**Re: Elan – Santa Monica Place
Conceptual Grading and Drainage Plan
No Engineer's Date (D18D054B)**

Based upon the information provided in your submittal received 10-16-14, the above referenced plan is not approved for Site Development Plan action by DRB nor Building Permit. Address the following comments:

CONCEPTUAL GRADING & DRAINAGE PLAN

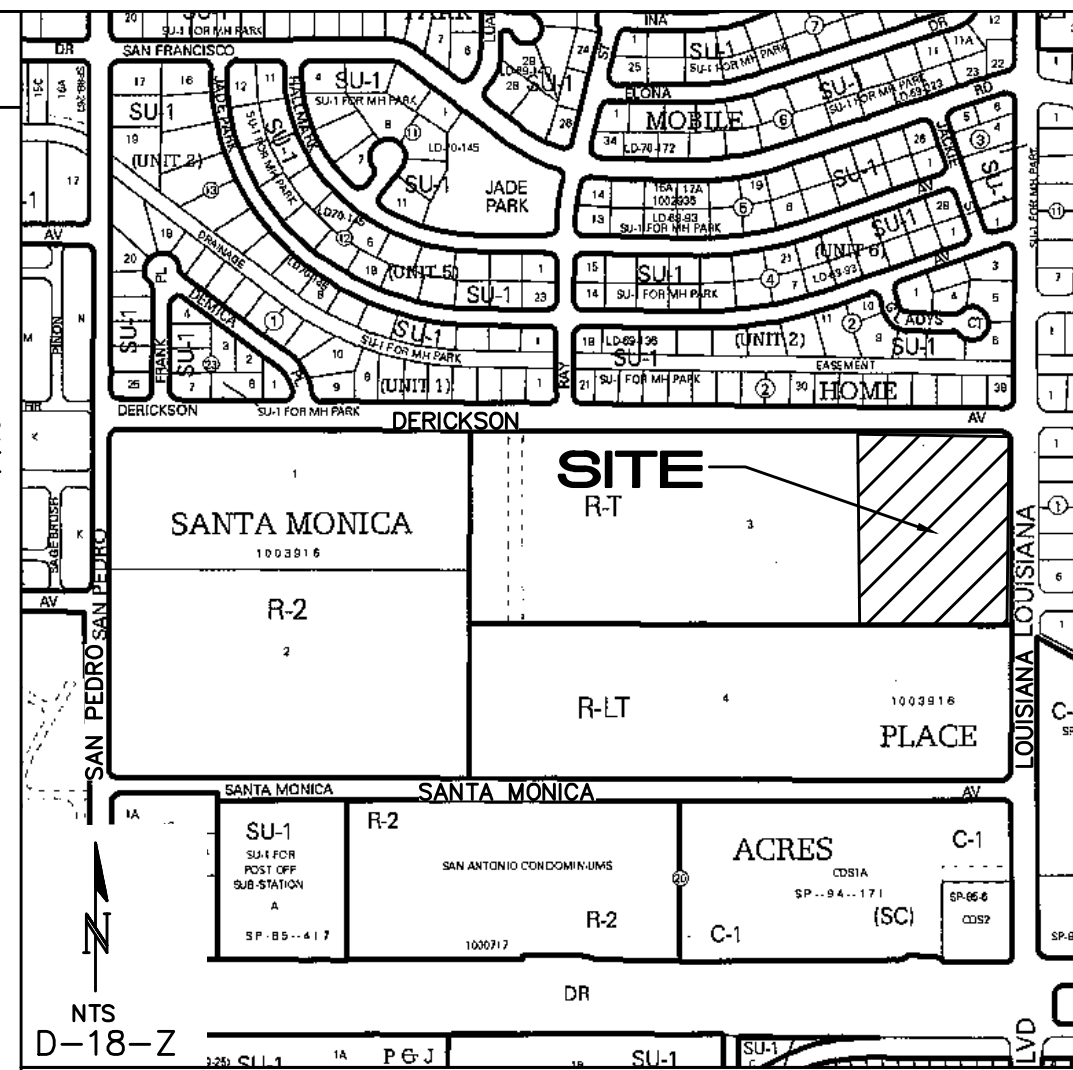
1. The Master Drainage Report for Tracts 3A, 3B, 4A, and 4B has been approved. The report specifies the drainage development parameters for the proposed Tract 3B (Elan's tract). Show how the site is meeting those requirements. All basins shown on this plan are discharging more than is allowable by the MDR. The allowable discharge for this site is 16.3 cfs not 23.8 cfs. Revise the calculations and narrative accordingly. Make sure the AHYMO run and the basin descriptions match also.

2. A discussion of the First Flush has been added to the plans. The volume required and the volume provided should be included also. Do you have sufficient room for the First Flush with the current site plan?
Per the City Drainage ordinance, the 90th Percentile Storm Event, which is 44 inches, is to be managed. Reduce 0.44 inch by the 0.1 inch for the initial impervious abstraction in Table A-6 of Section 22 of the DPM. Multiply the remaining 0.34 inch by your impervious area. This is the portion to retain.

Date:	No. Revision:	Date:	Job No.
9/10/14			2047
Drawn By:			CG-102
BJB			
Ckd By:			SH2 OF 2
FCA

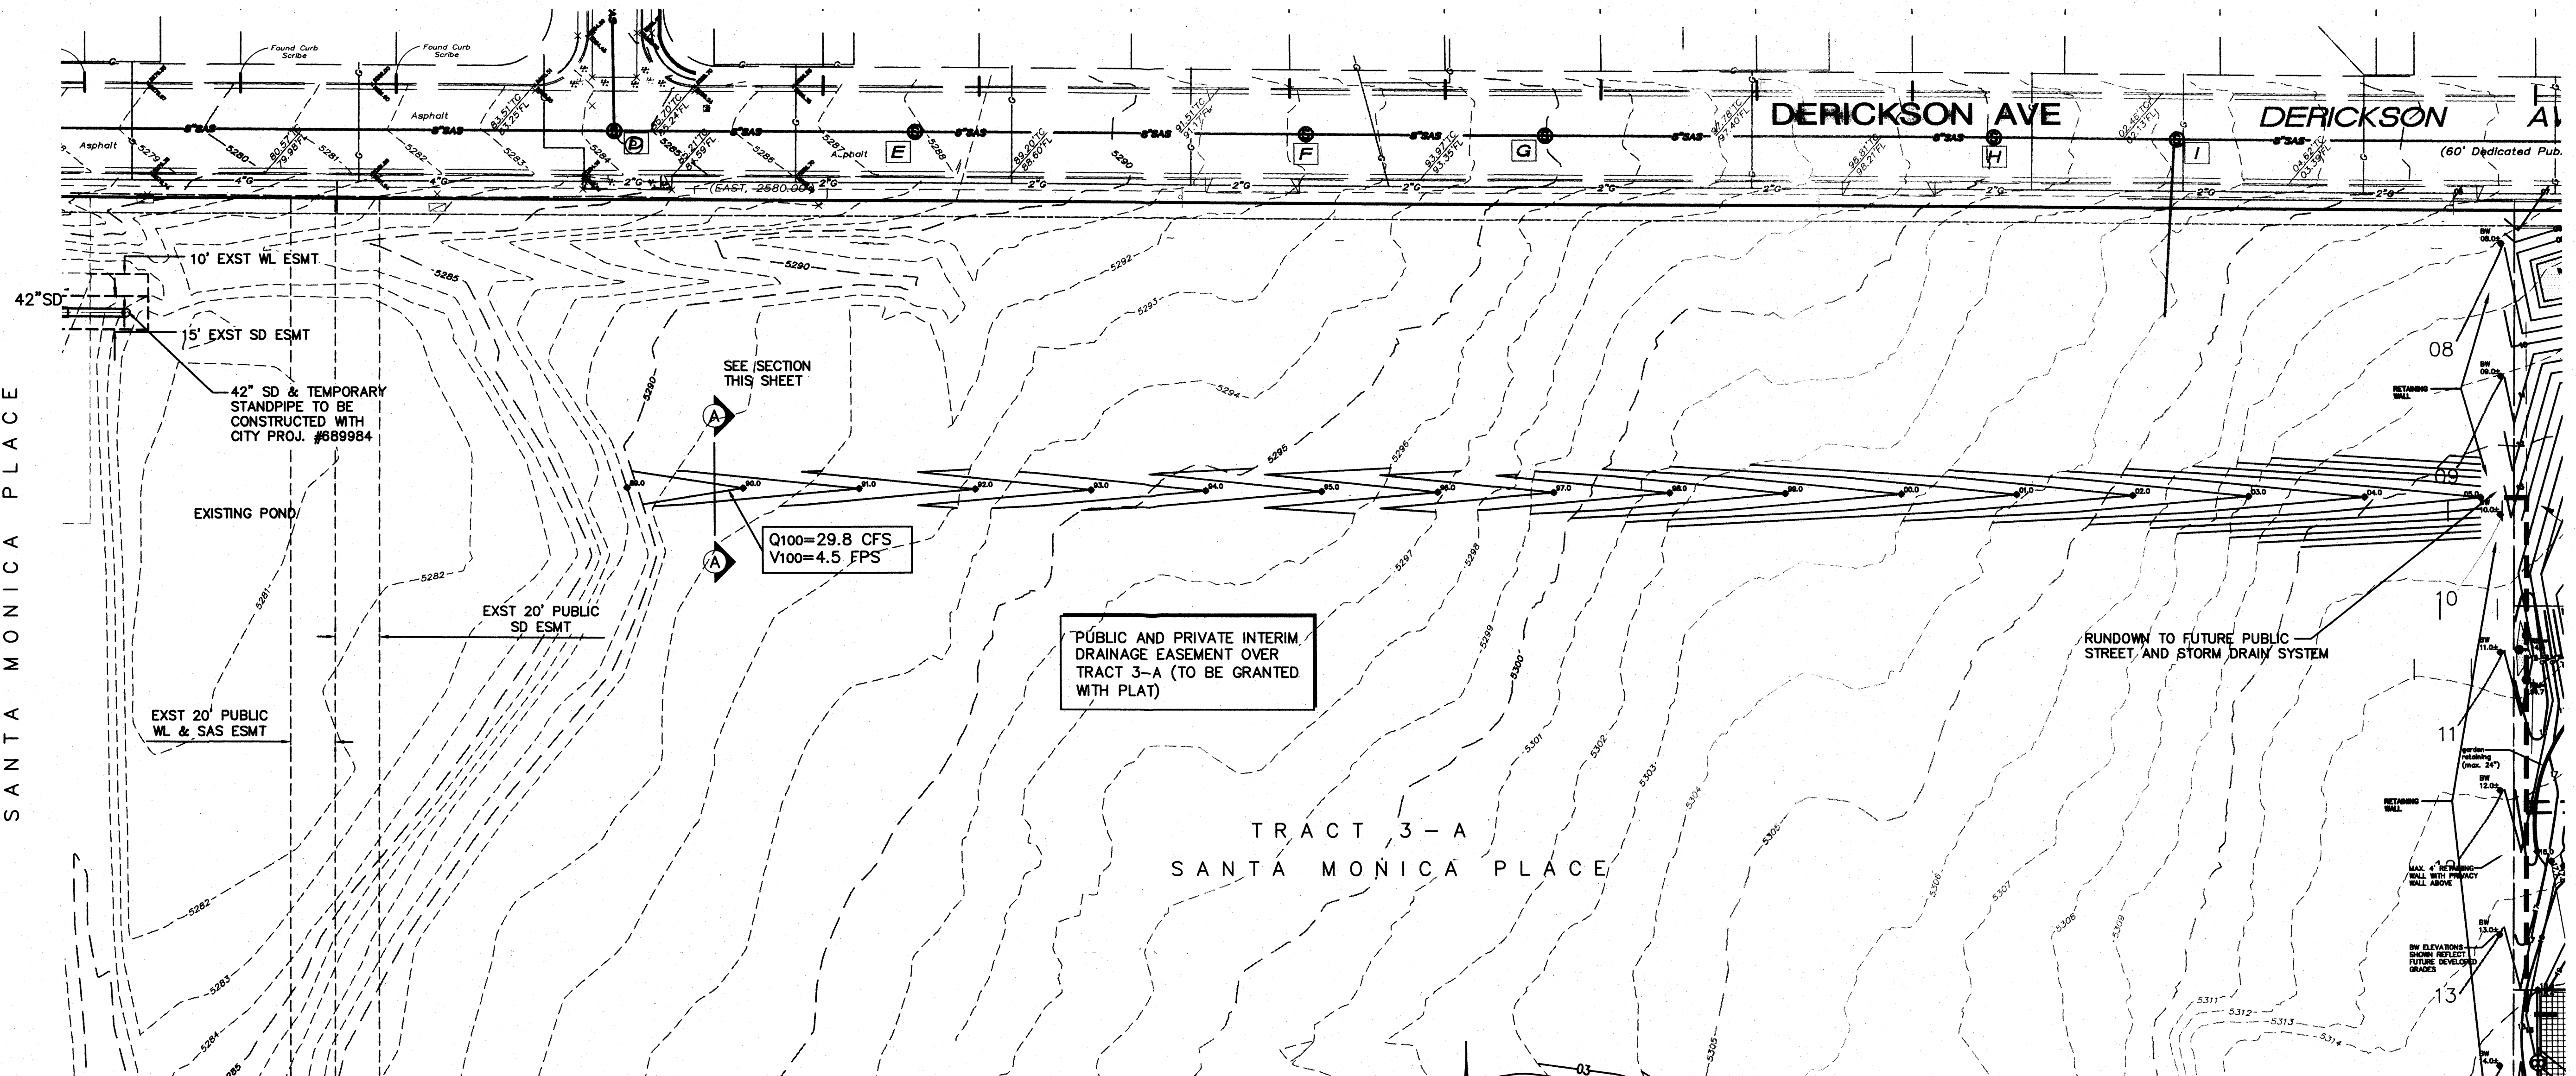
3. Include the design for Channel A on Tract 3A with your Grading and Drainage Plan.
